From: Sarah Burrow <Sarah.Burrow@arun.gov.uk>
Sent: 27 April 2021 16:49
To: Planning.Responses <Planning.Responses@arun.gov.uk>
Cc: Anita Gardner <Anita.Gardner@arun.gov.uk>
Subject: RE: Planning Consultation on: WA/21/21/DOC

Engineers Comments Regarding Surface Water Drainage

Application No: WA/21/21/DOC

Site Address: Wandleys Farm Wandleys Lane Walberton BN18 0QR

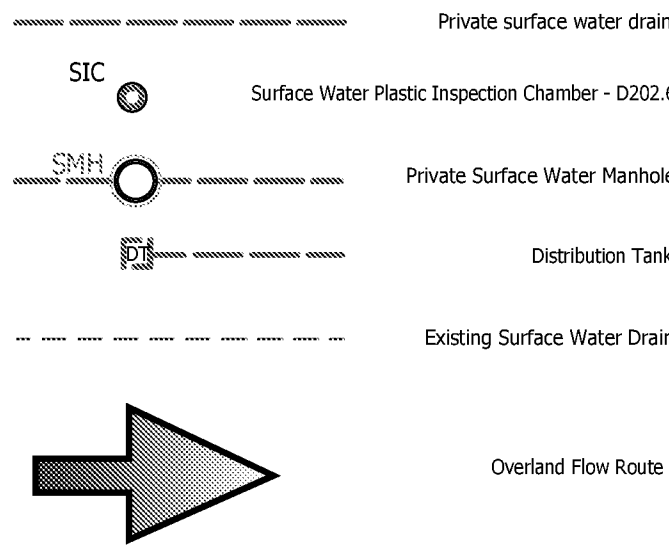
1. Please provide an impermeable area plan.
2. Please mark out the two different Hydrobrake model numbers on the drainage layout.
3. Please provide surveyed levels for the watercourse invert and top of bank. Please also model for a surcharged outfall. (Water at top of bank)
4. Please include a note to state what type of pipes are proposed (material). If the materials vary across the site, state as such.
5. Please include a note stating which cover types to use on inspection chambers/manholes on the drainage layout.
6. Please include sumps or silt traps upstream of all connections to permeable paving.
7. No construction detail drawings have been provided, please provide the following construction detail drawings:
 - a) Pipe bed and surround
 - b) Permeable paving including diffuser blocks.
